Suggestions for ExQ2 (response to Applicant's D2 submission)

The Second Written Questions would be an opportunity for the ExA to seek clarity on some practical and technical conflicts in the BWSF proposal.

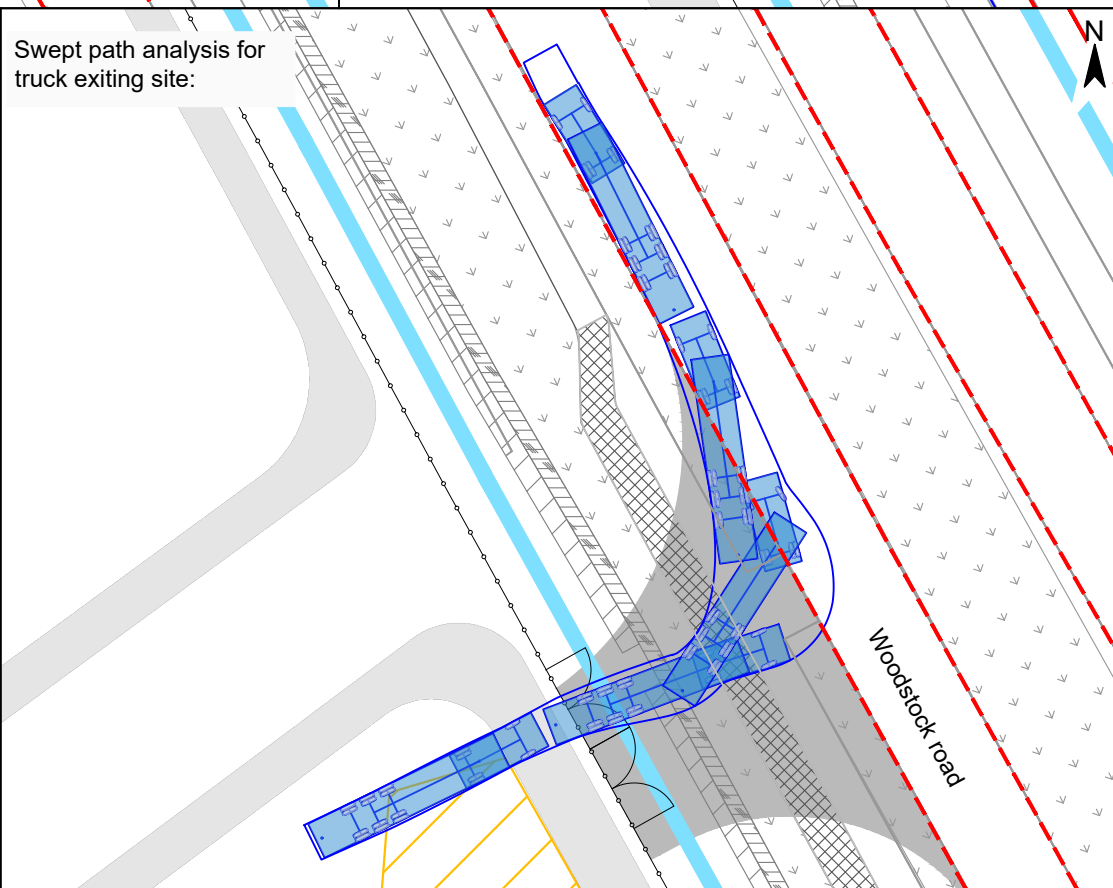
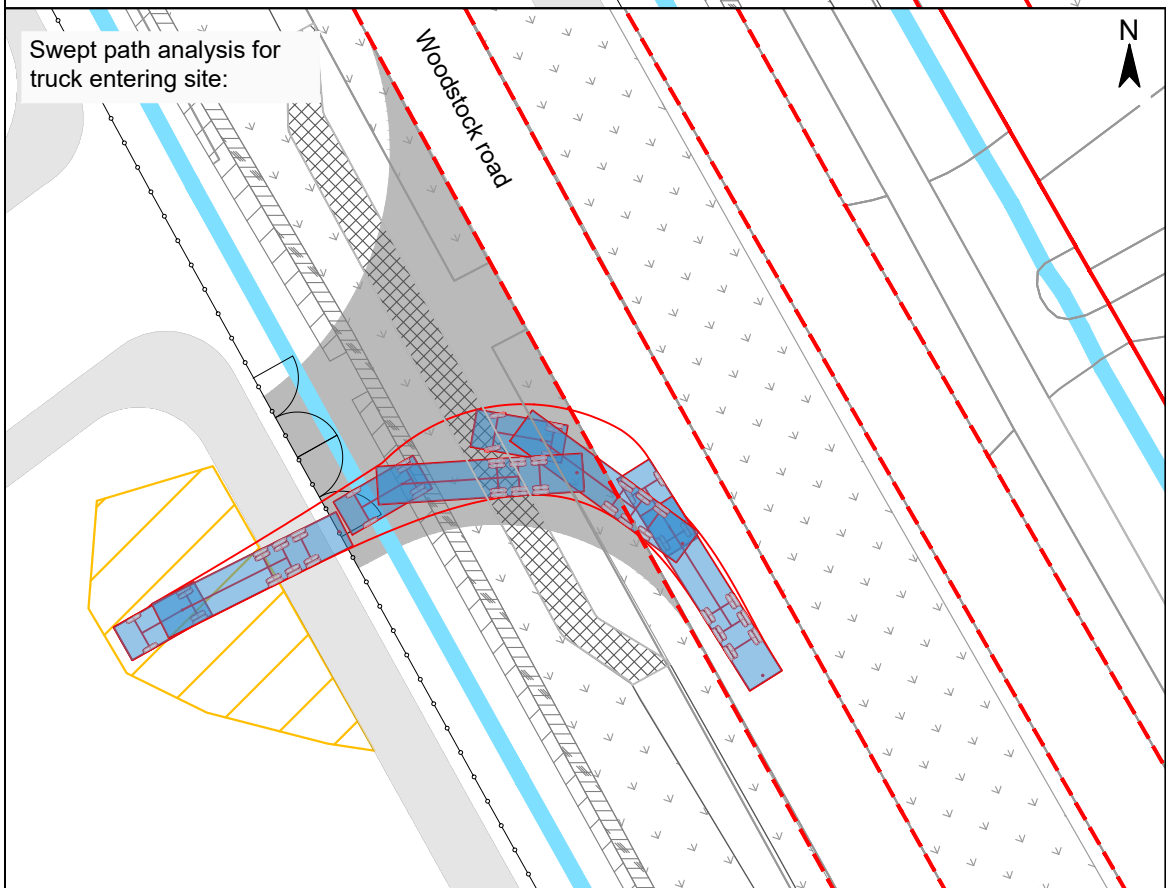
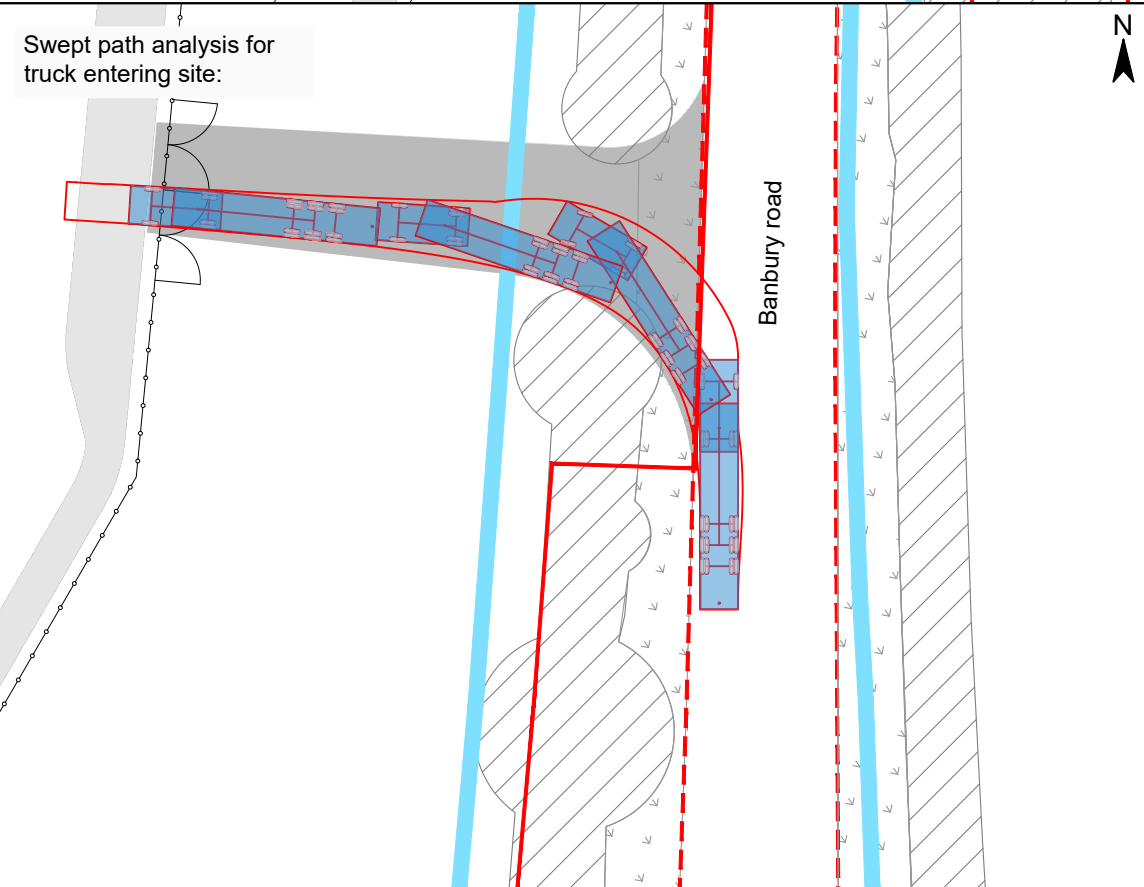
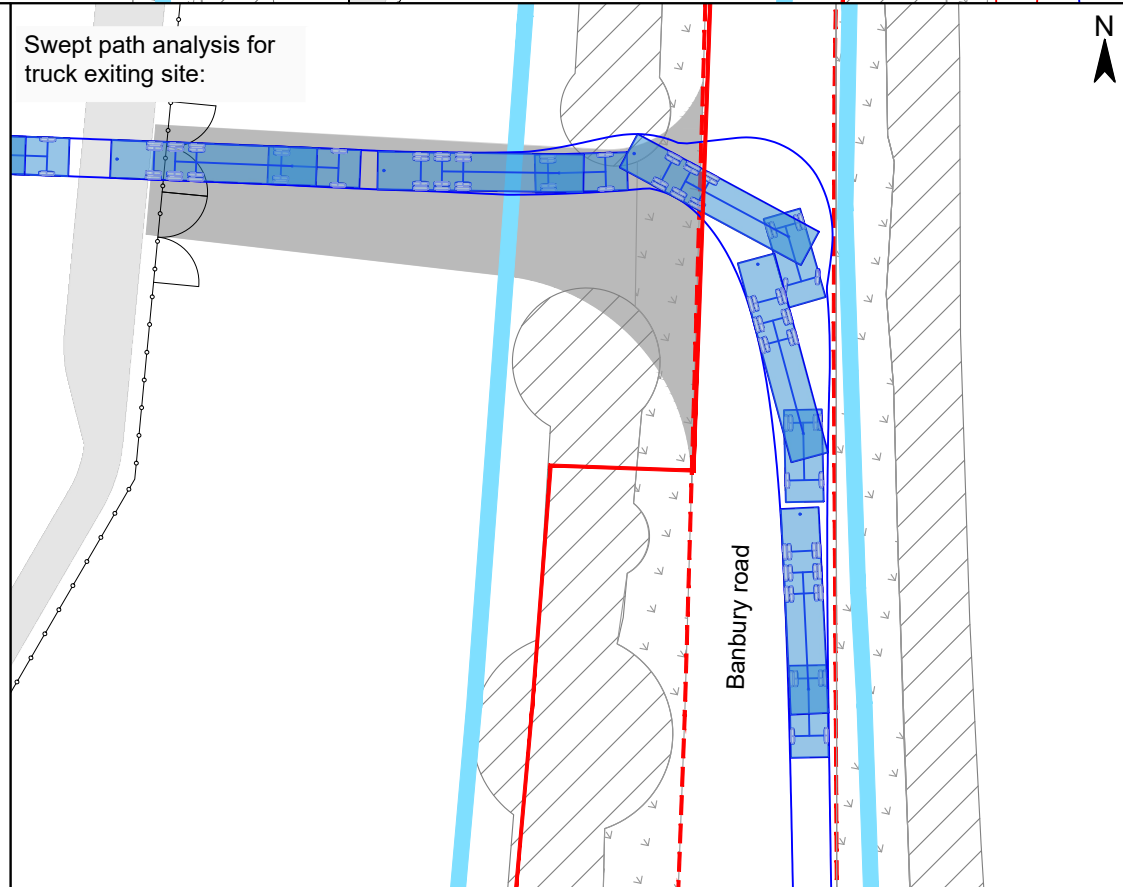
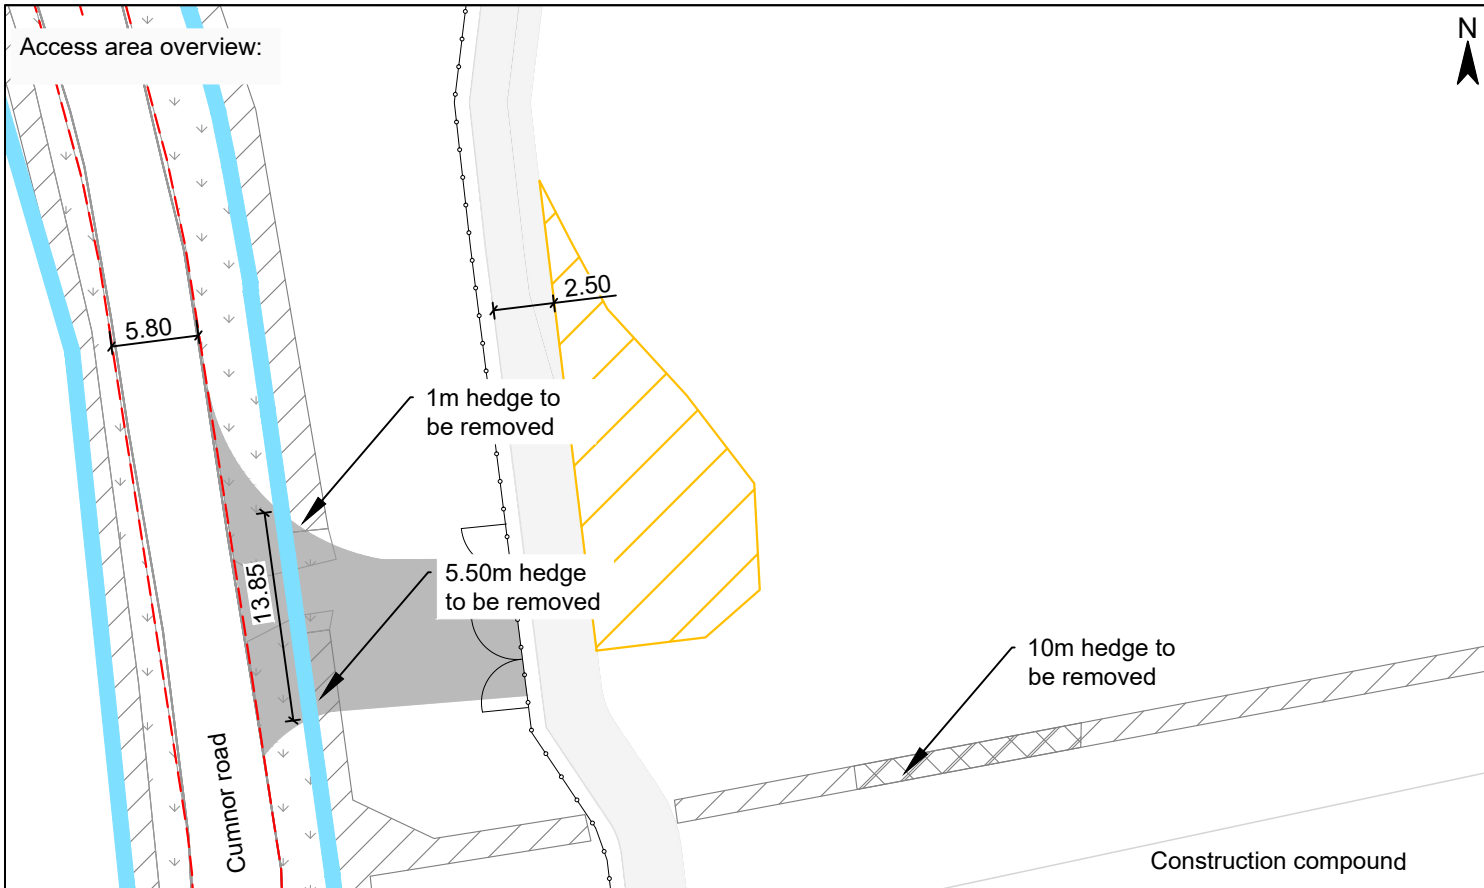
- 2) Delete the theoretical mini-tables. Prospective table suppliers can advise the minimum real-world table length (8 metres?).
- 3) An HGV (e.g. fire tender, PCS-delivery articulated lorry, livestock transporter) is 2.5 metres wide. It will not be able to negotiate *any* curve on 2.5-metre-wide track, let alone the tight-radius curves shown. 'Swept-path' analysis (as incorrectly claimed [[REP2-027](#), p56]) was used only for the access routes from the highways.
